Your ref: 3/2016/1064

Date: 12th December 2016

Planning Application 3/2016/1064: Replacement garage at Bank House, Sawley Road, Grindleton, Clitheroe BB7 4RS

Plan

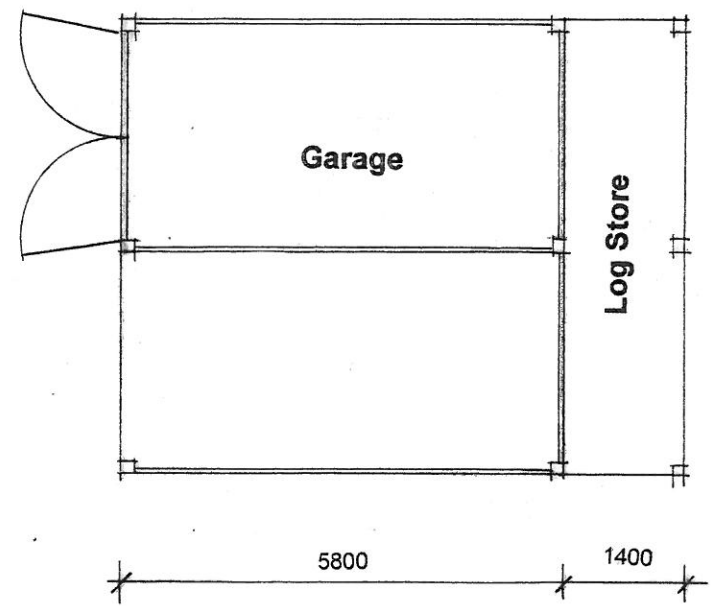
Also seen on Street View and the proposed plan is an extant double garage, sited closer to Sawley Road and between the proposed site and Bank House. As noted in the heritage Statement the proposed site is at a lower level than Bank House and as such will have limited, if any, impact (or indeed visual connection) on Bank House. It is, however, only some 20m or so from the Listed Bank Hall and lies uphill from that site. It will also tend to remove the existing 'green break' between Bank Top Farm/Bank House and Bank Hall/Bank Lodge.

Given that it is proposed to place the building on the extant concrete slab no archaeological condition is considered necessary. With regard to the siting and setting issues, however, you may wish to get an opinion from the Council's Conservation Team.
